February 29, 2016

**Re: Storage Facility for Derron Havehor**  
**809 Locust St., SE**  
**Traffic Circulation Layout**  
Engineer's/Architect's Stamp dated 2-15-16 (K15-D096)

Based upon the information provided in your submittal received 2-22-16, the above referenced plan cannot be approved for Building Permit until the following comments are addressed:

1 TRAFFIC CONTROL PLAN
Scale: 1" = 10'-0"

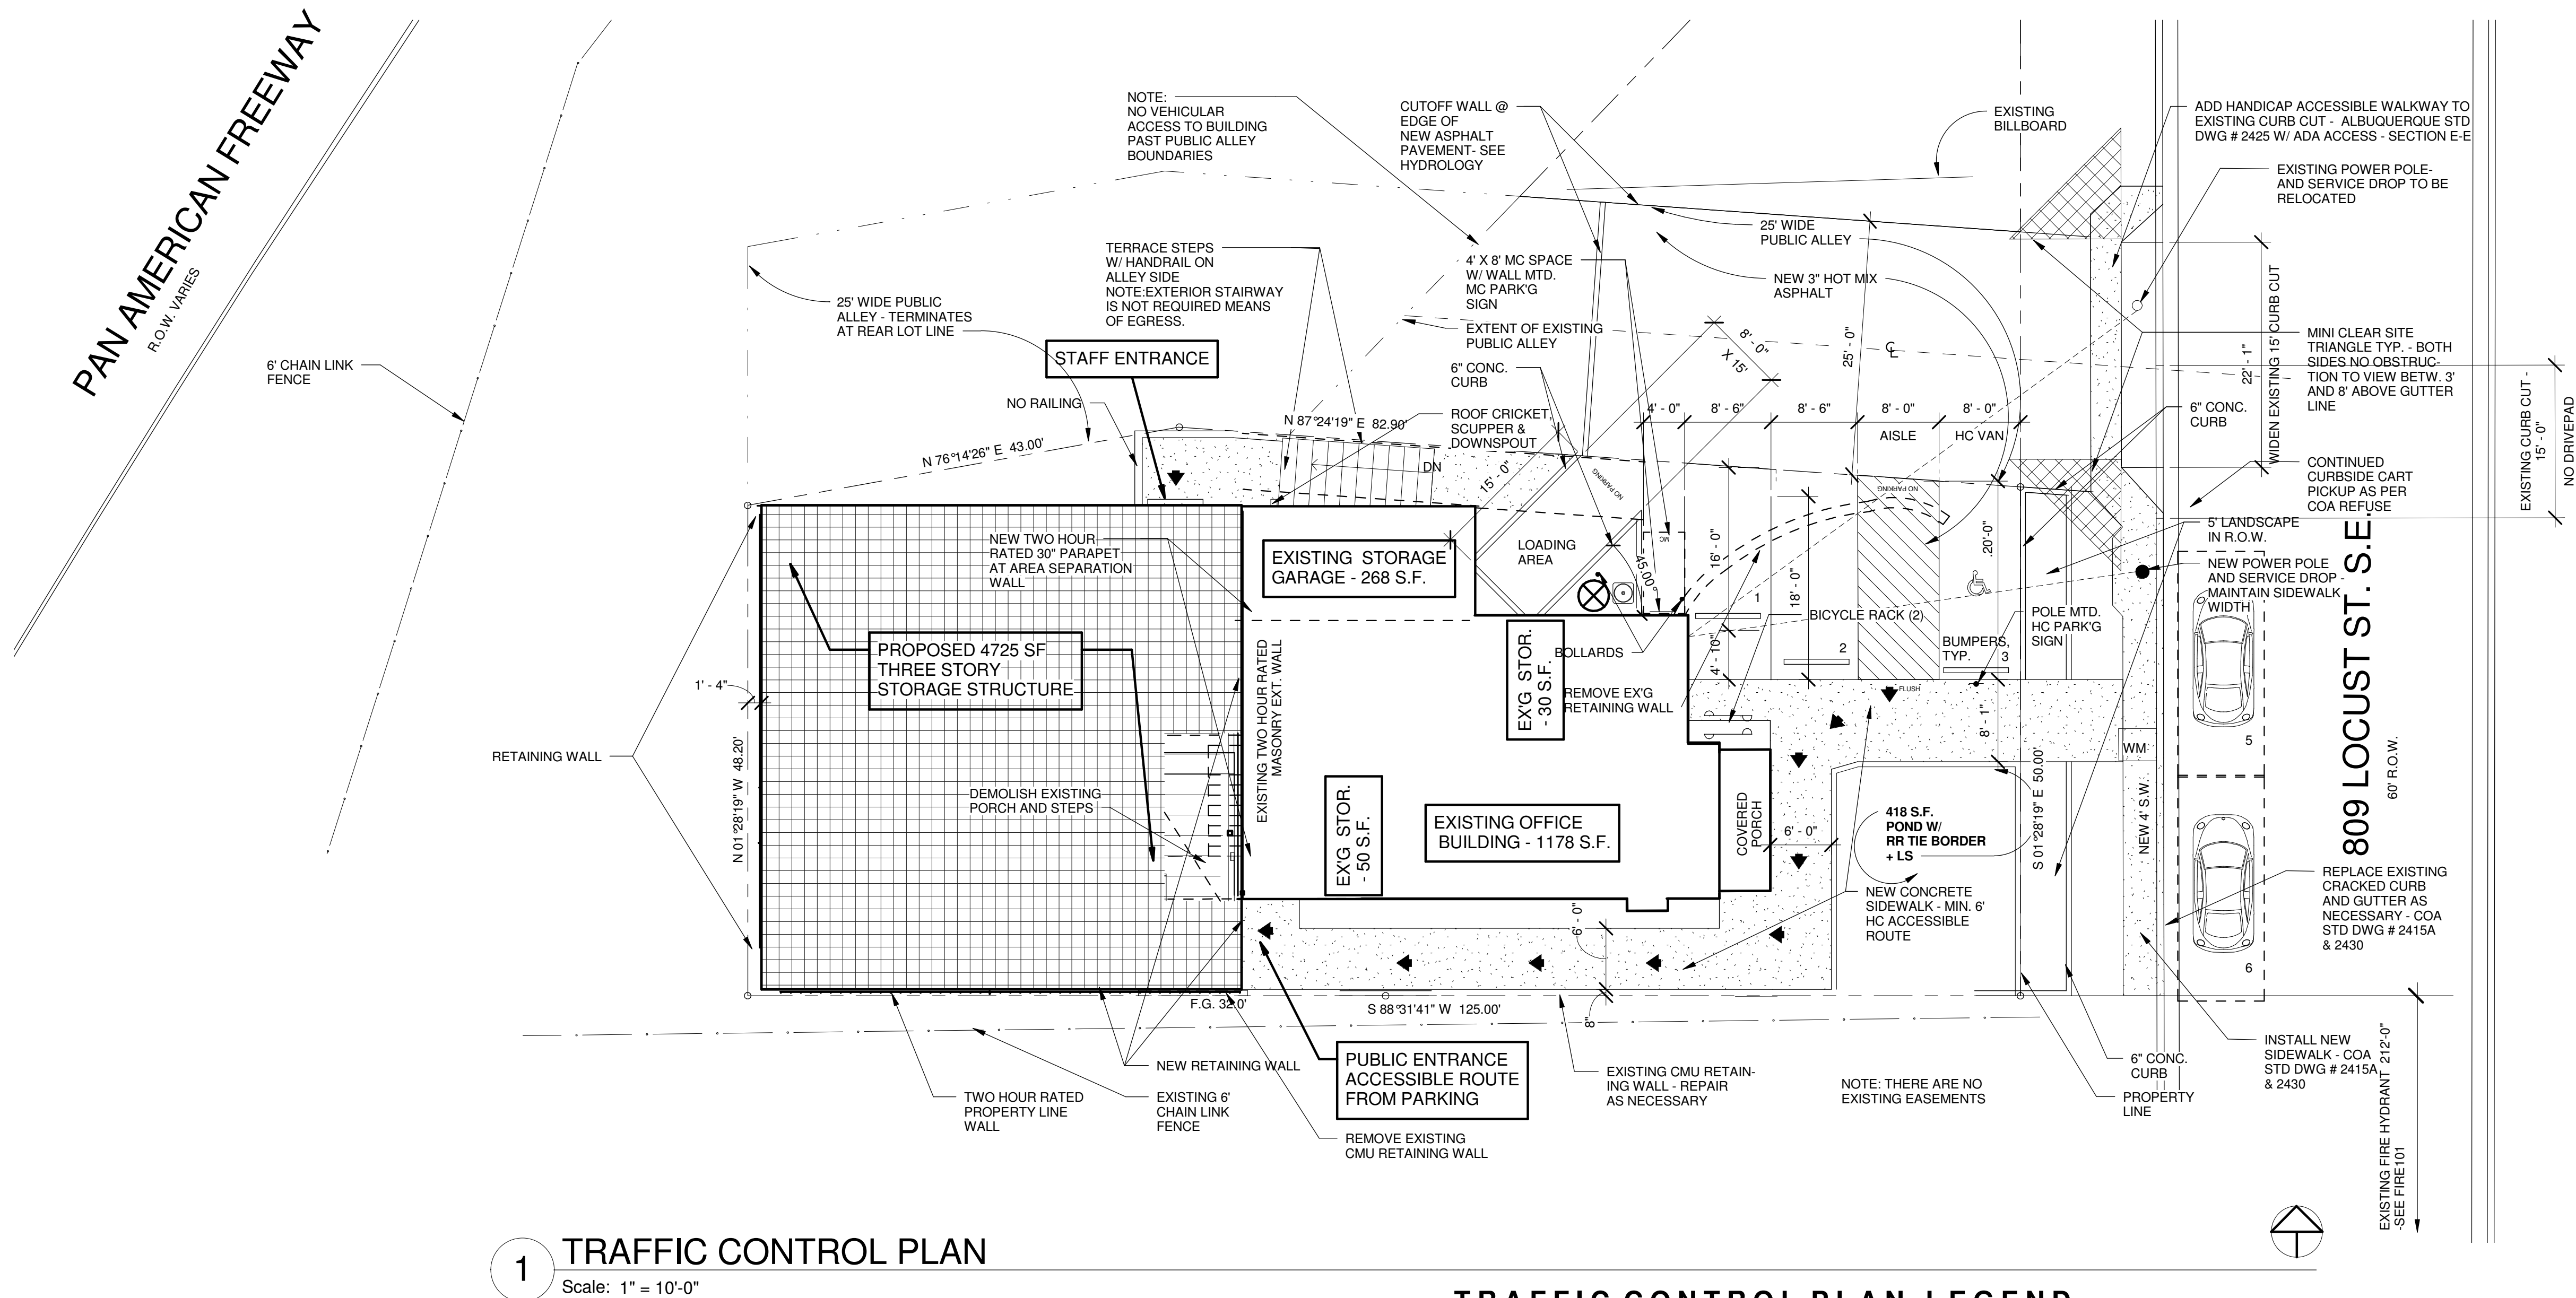
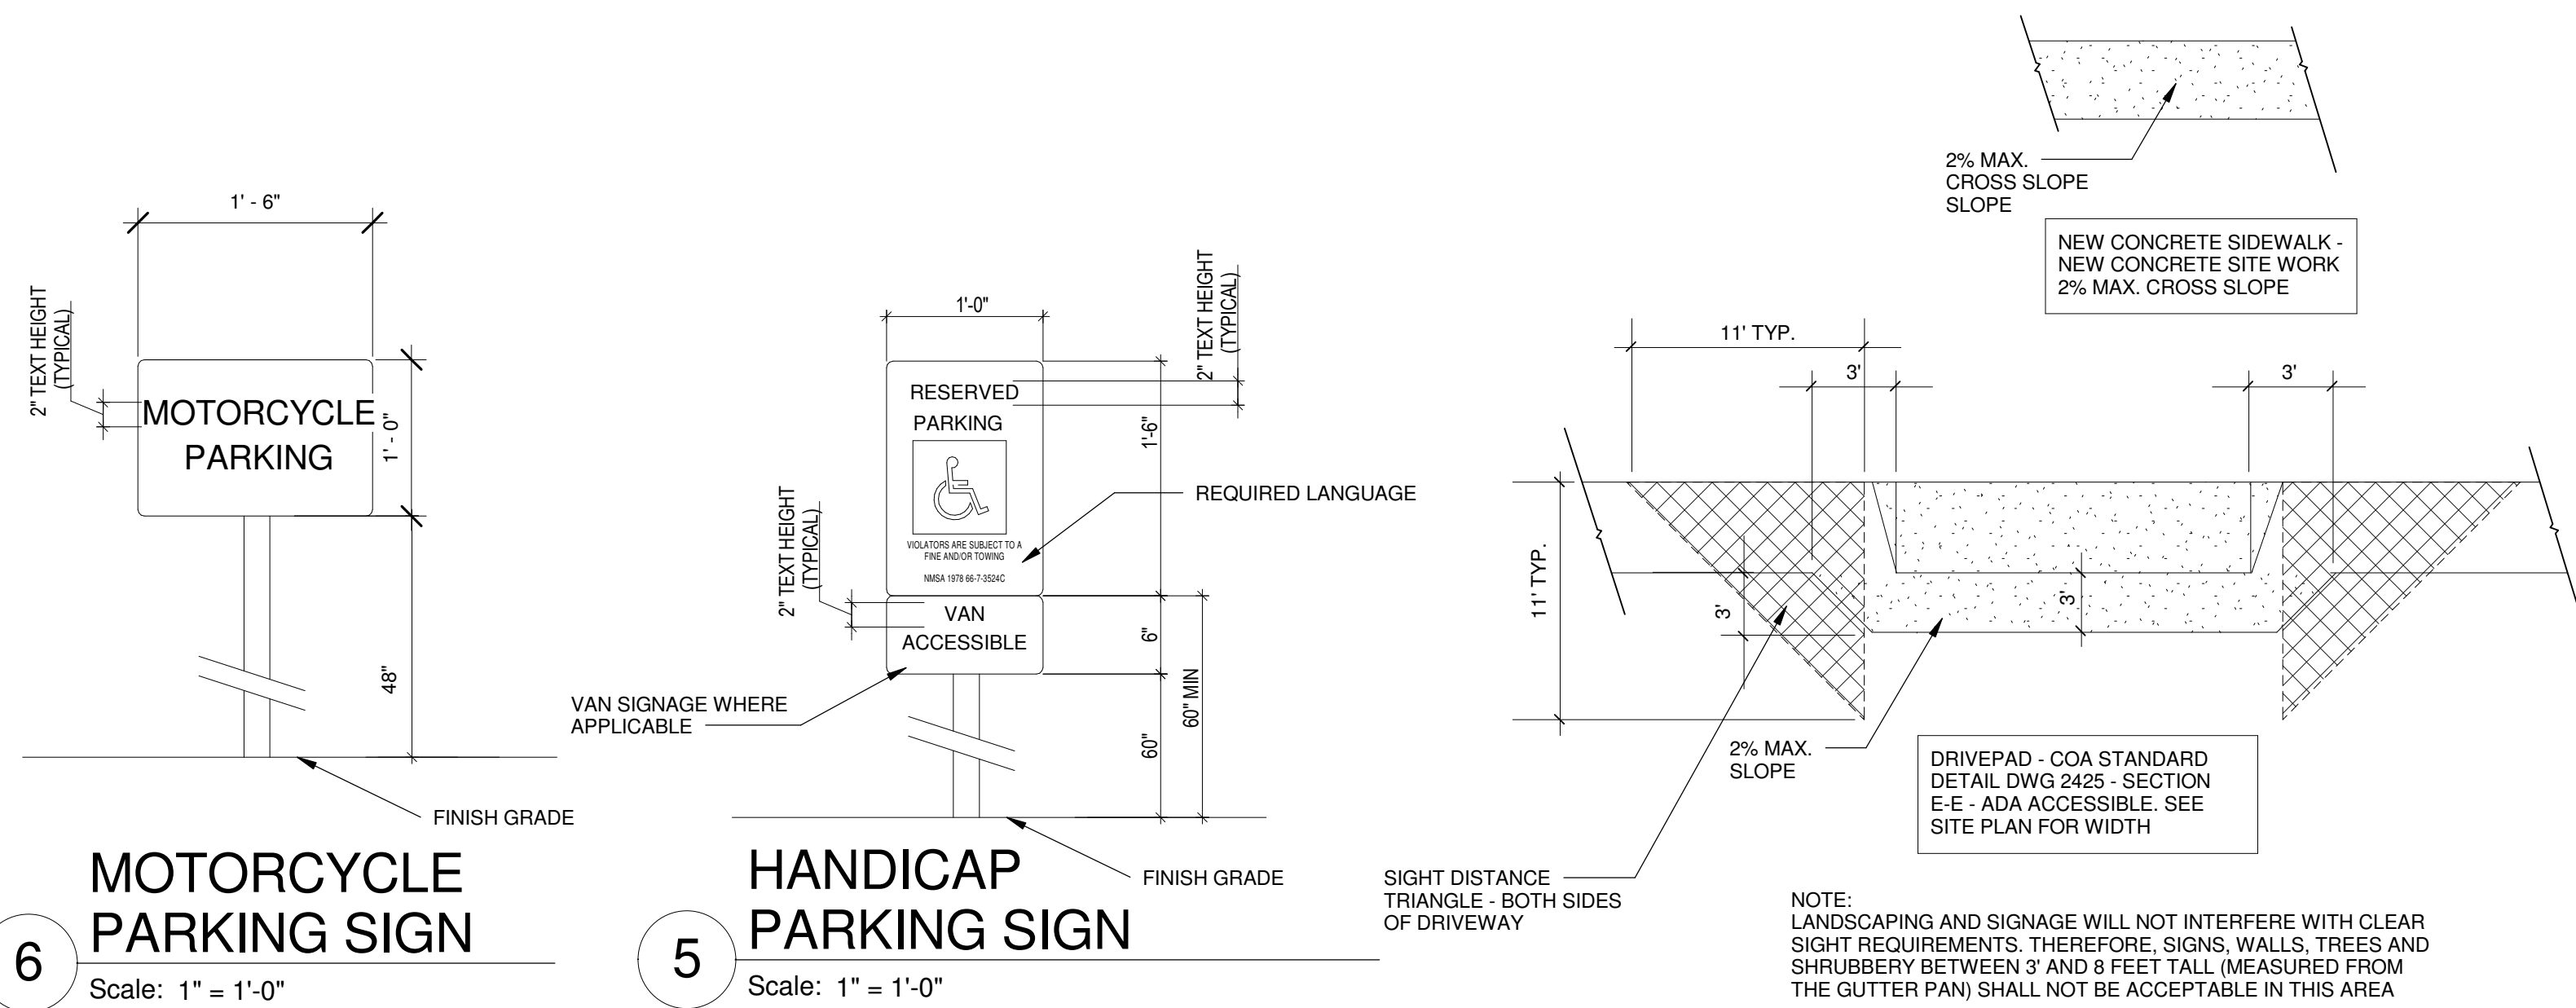
1. Please show two approved on-street parking spaces on resubmittal drawing.
2. Identify all existing access easements and rights of way with dimensions.

3. Please list the width and length for all parking spaces.
4. Per DPM, there must be more than 20 parking spaces in order to qualify for use of compact parking spaces. Parking space No. 1 and 4 do not qualify as a Compact parking space. Please reconfigure parking spaces to meet DPM requirements.

5. Show all drive aisle widths and radii. Please detail the distance from the parking spaces to the either edge of the proposed new asphalt.
6. Per the DPM, a 6 ft. wide ADA accessible pedestrian pathway is required from the HC parking stall access aisles to the building entrances. Please clearly show this pathway. Please dimension pedestrian pathway width between covered porch and ponding area curb barrier.

7. Provide a min 6" or max 8" high concrete barrier curb or other acceptable barrier between landscaping and parking areas and/or drive aisles. Please call out this detail for all required barrier points.

8. Design delivery vehicle route needs to be shown.
9. Please detail vehicular access and load/unloading areas to proposed storage structure.
10. Service vehicle and/or refuse vehicle maneuvering must be contained on-site; provide a copy of refuse approval. Please show location of refuse container.

11. See Chapter 23, Section 6 of the City of Albuquerque *Development Process Manual*, for appropriate drive pad widths. Per DPM, the drive pad entrance must be a minimum of 25 ft. wide.

12. Unused curb cuts must be replaced with sidewalk and curb & gutter. A build note must be provided referring to the appropriate City Standard drawing.
13. All broken or cracked sidewalk must be replaced with sidewalk and curb & gutter. A build note must be provided referring to the appropriate City Standard drawing.
14. Please include a copy of your shared access agreement with the adjacent property owner.
15. Please include two copies of the traffic circulation layout at the next submittal.
